Application No: AB/126/20/HH
Site Address: 38 Dalloway Road Arundel BN18 9HW
Description of works: Two storey rear extension, replacement windows, replacement cladding, infill to side void & installation of a fence.

Thank you for your internet representation made on 1st January 2021 which has been recorded as an objection with the comments as follows:

BLOCK PLAN
[proposed]

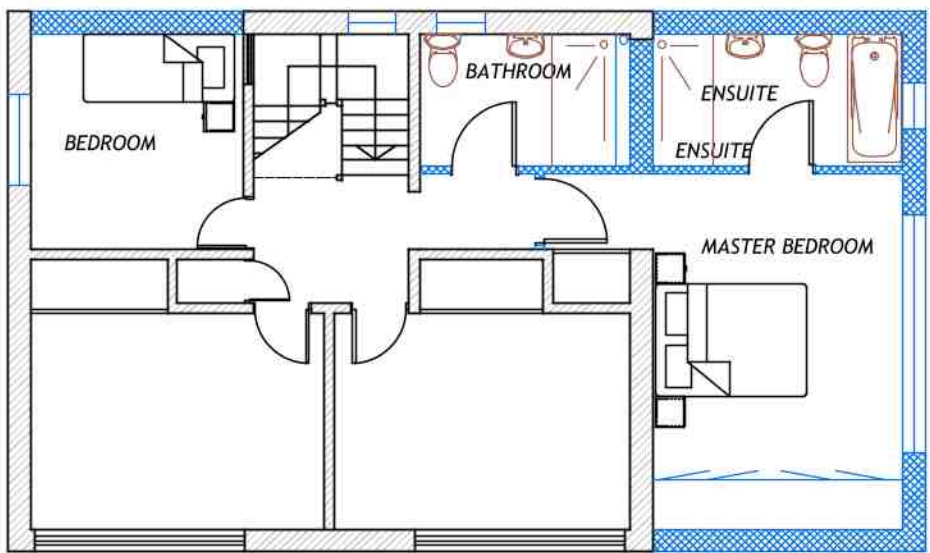
I am concerned about what type of fencing is planned in this application. Most of the nearby houses have open plan front gardens, which gives a pleasant open feel to the area, and if the planned fencing is standard 6 foot (or higher) fence panels, I think it would look odd.
If fencing is deemed essential, then perhaps a lower, more open style post and rail type fencing would be more appropriate and fit better with the area.
